New Maitland Hospital

Stage 2 - State Significant Infrastructure (SSI 9775) Application - Consultation Summary

APPENDIX A – GOVERNMENT ARCHITECT NSW – MEETING NOTES AND DESIGN RESPONSE (BVN Design Report)

3.2 RESPONSE TO GOVERNMENT ARCHITECT CONSULTATION MEETING #1 20 FEB 2019

main avenue and forecourt - detail plan

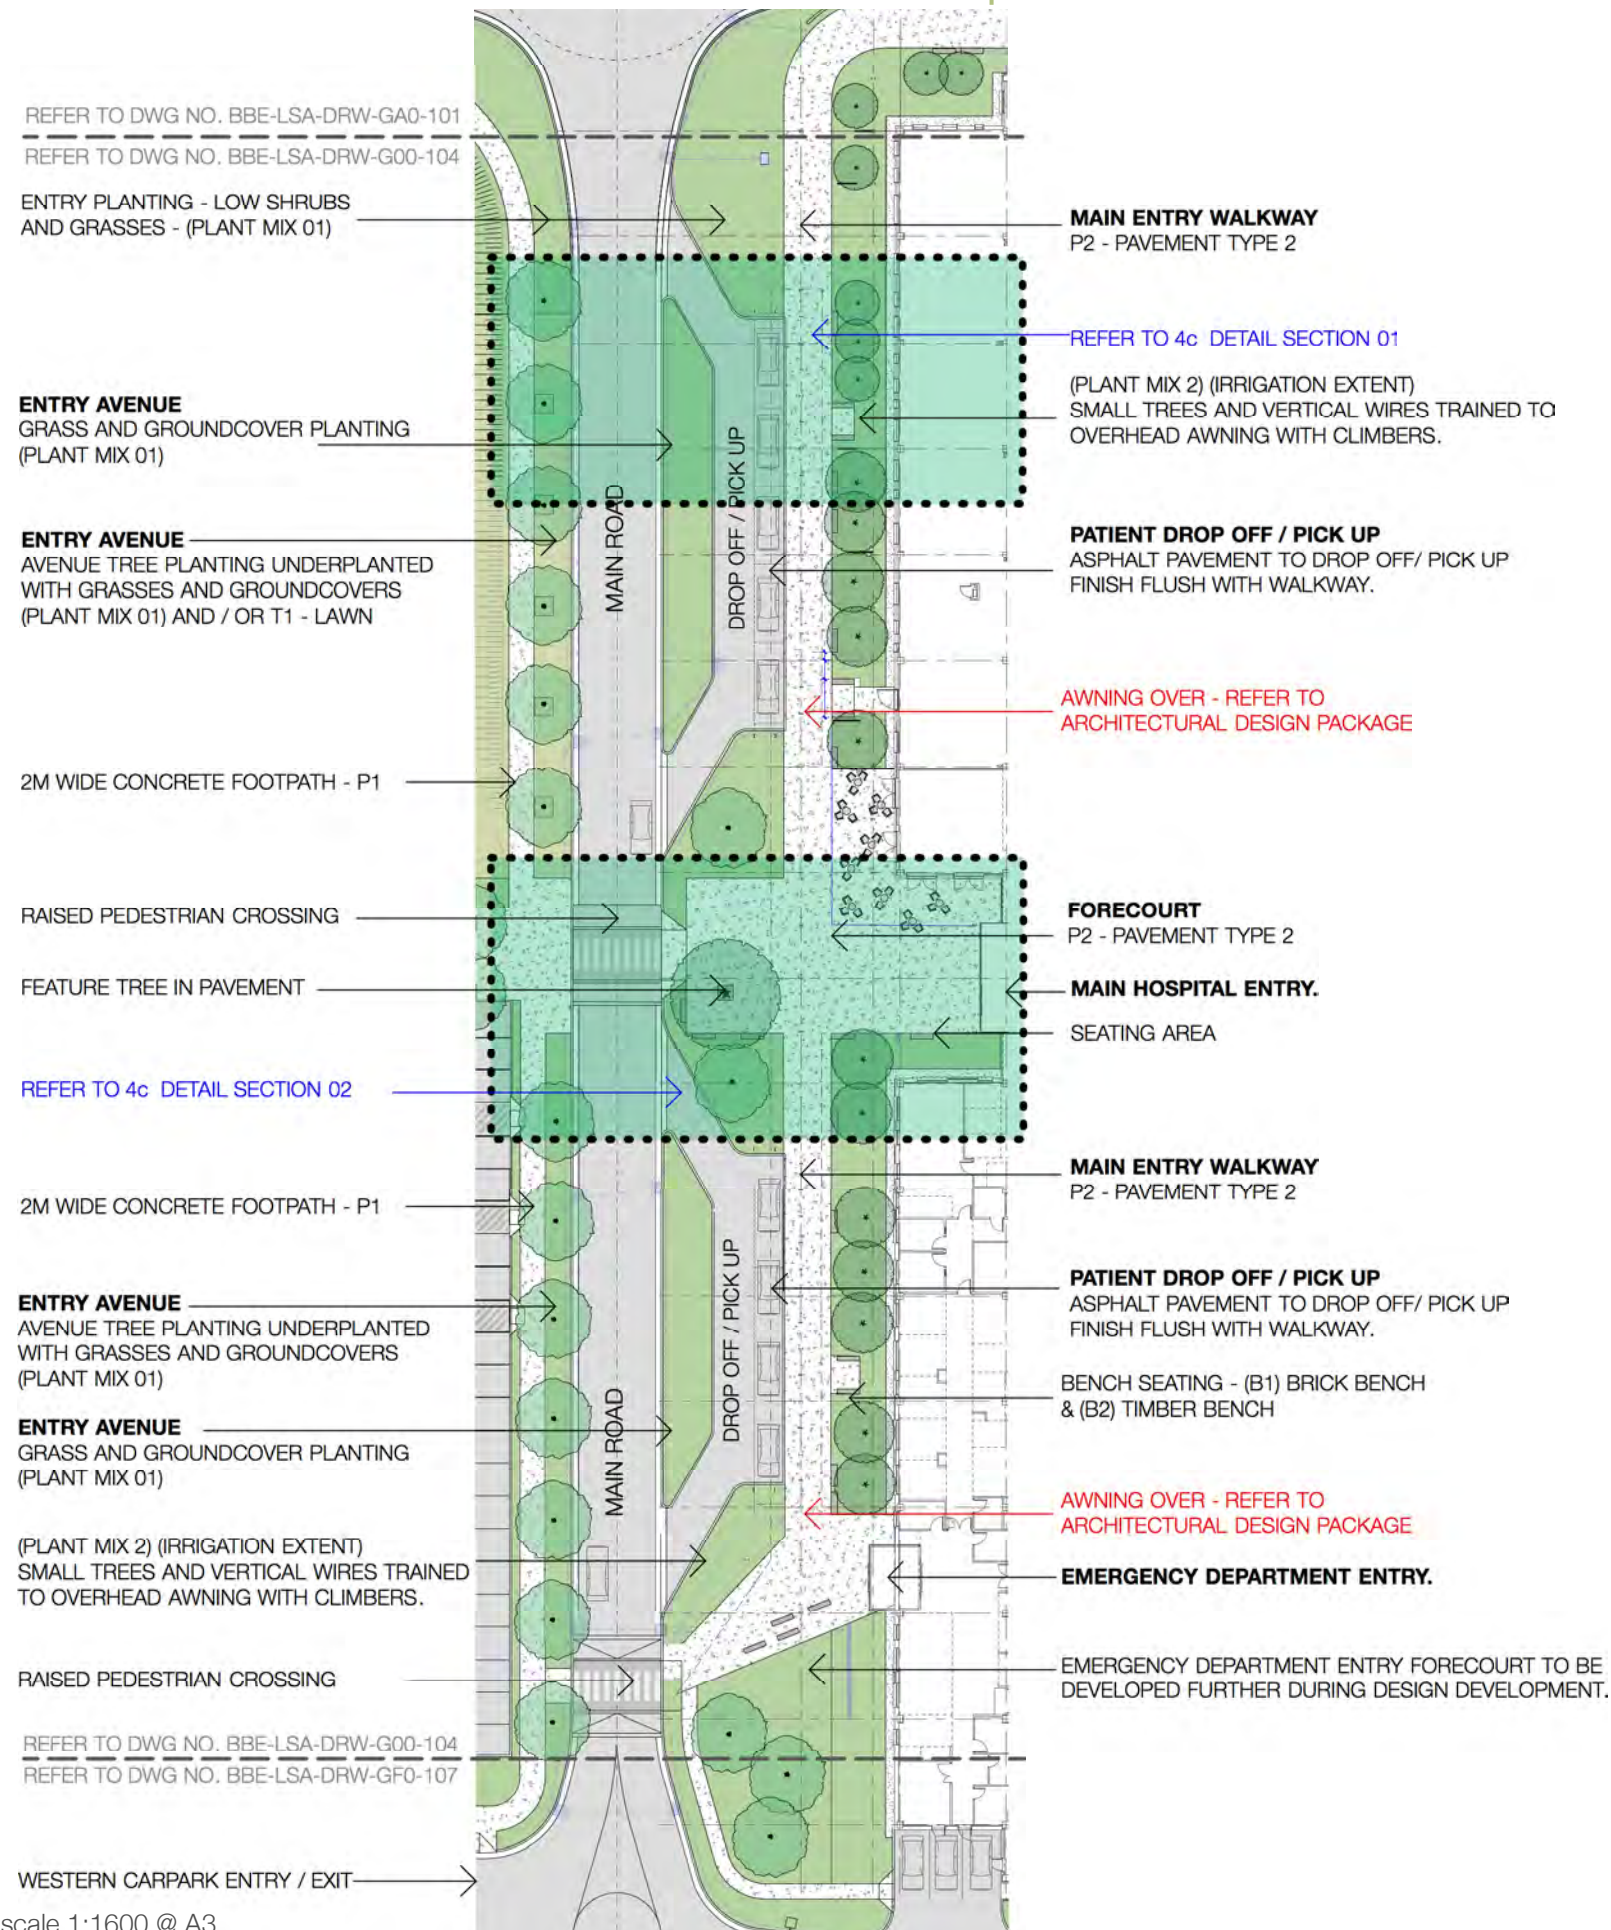
6. Clarify access to and usability of the landscape area located between Metford Rd and the public drop-off zone;
7. Pursue the development of a civic square outside the main entry to further reinforce the pedestrian character of this area;

- Direct pedestrian crossing from western carpark to Emergency Department.
- Amendments to the carparking areas to clarify circulation and minimise conflicts between vehicles and pedestrians.

- Extension of the main entry towards the western landscape through the creation of a public plaza and pedestrian zone.
- Direct pedestrian crossing from western carpark to Emergency Department.
- Amendments to the western carparking areas to clarify entry / exit circulation and minimise conflicts between vehicles and pedestrians.
- Incorporation of landscape areas within the harbour zone and around the main entry.
- Provision of outdoor seating to retail tenancy.

This plan will be further developed to incorporate seating along the edge of the western landscaped area

4.0e northern road and carpark - detail plan

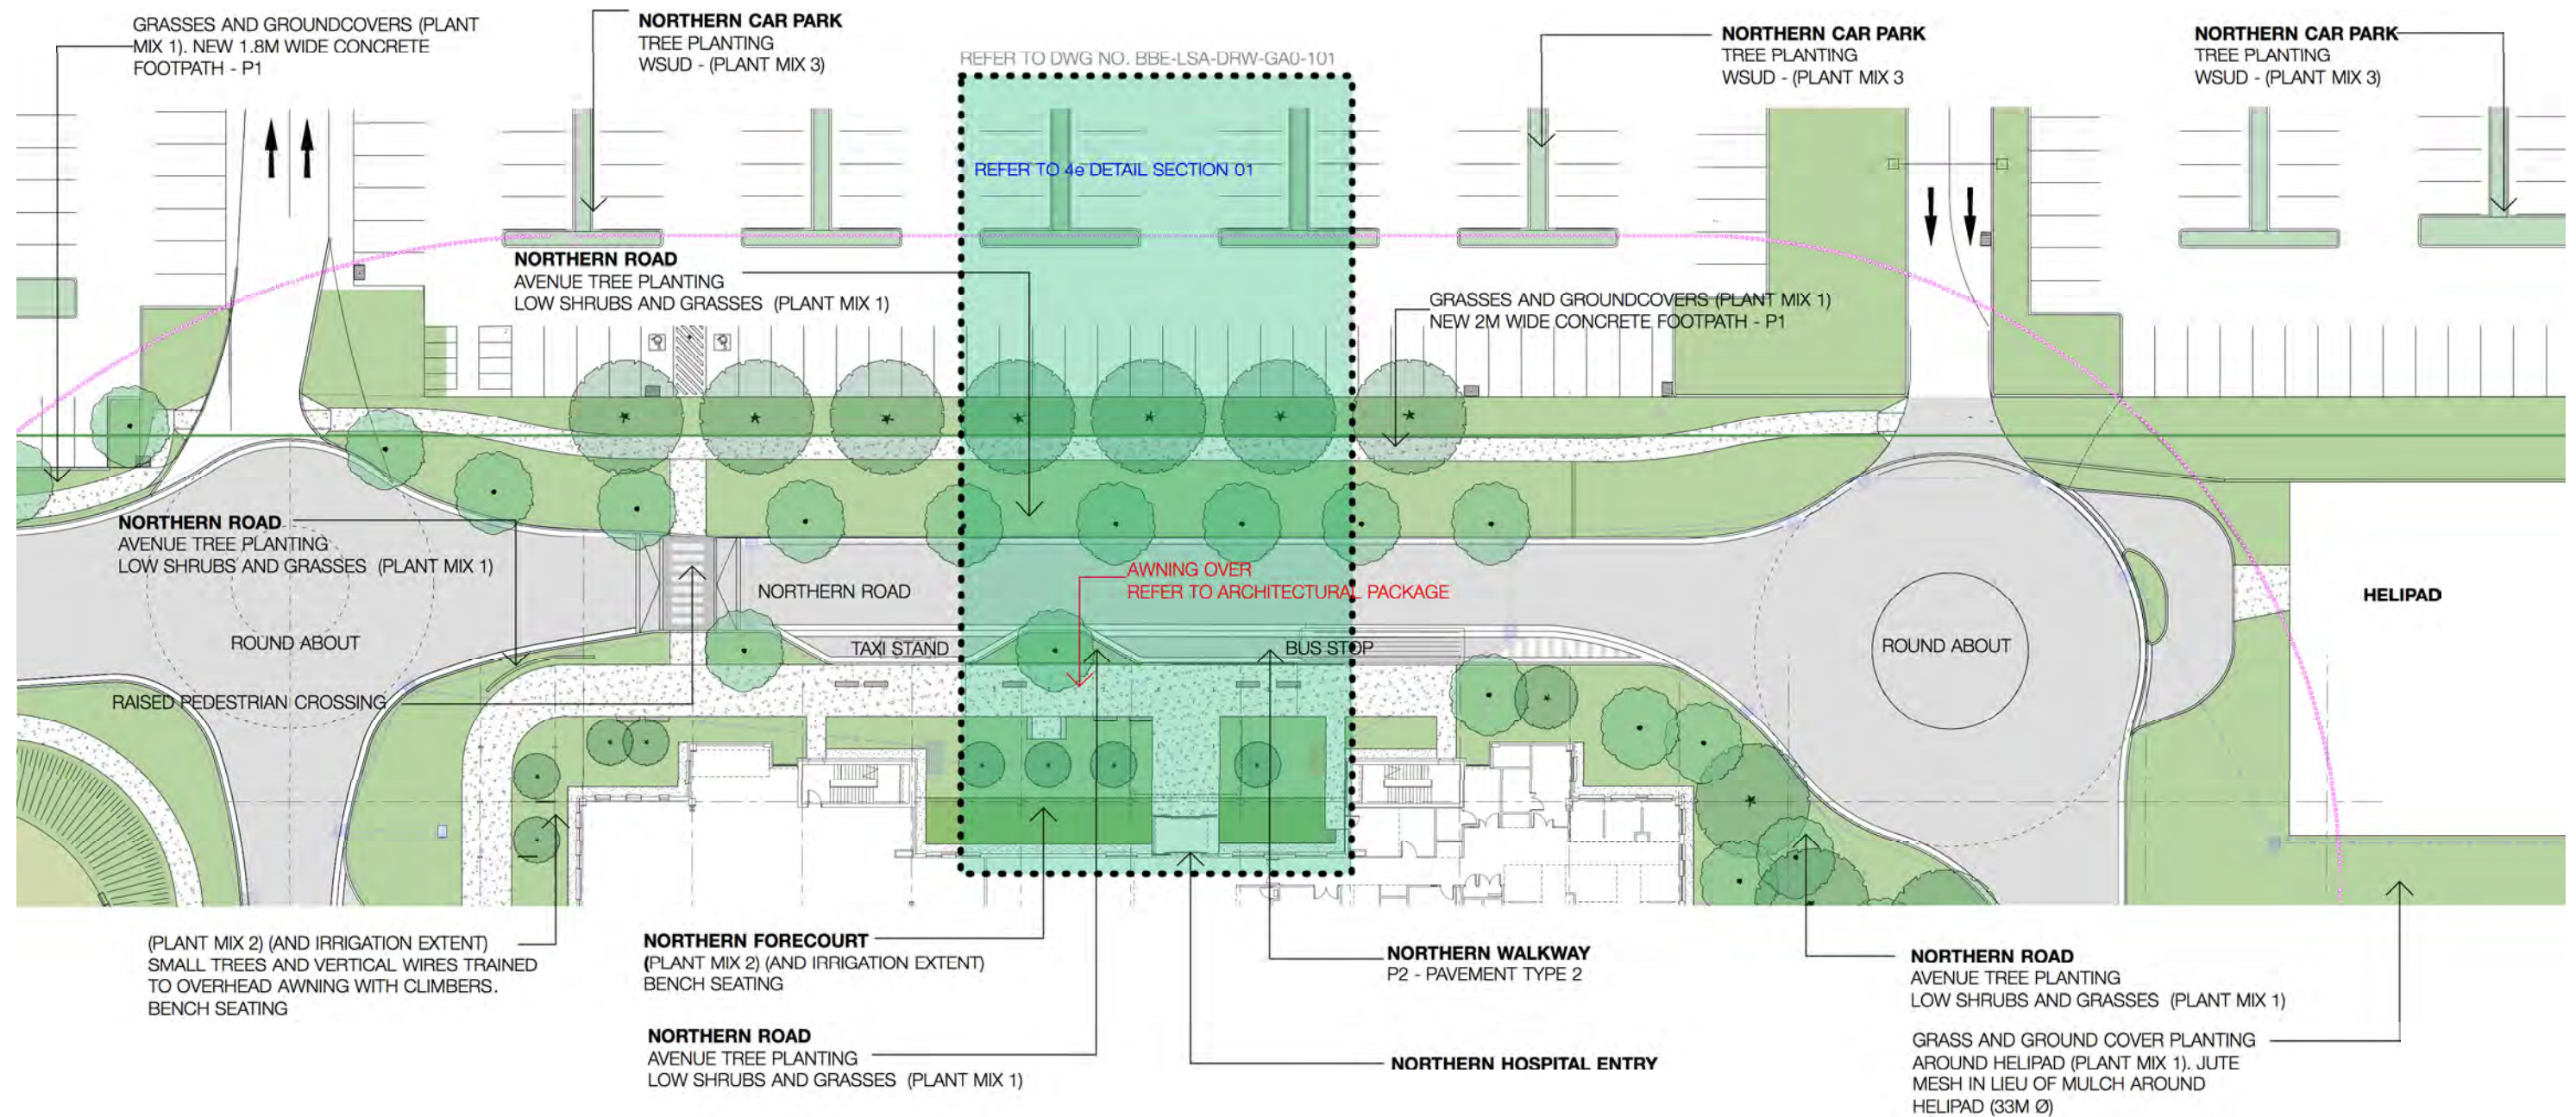
3. Landscape and provide access to both internal courtyards on level 01;
4. Incorporate windows to the ends of the corridors at each IPU wing;
5. Minimise the heat-island effect by maximising use of landscape and shade trees to all surface carparking areas;

Wider landscape areas between car parking bays have been incorporated in line with commentary from the initial panel review. This includes planting width for shade trees and stormwater treatment. This was presented at the second meeting and supported.
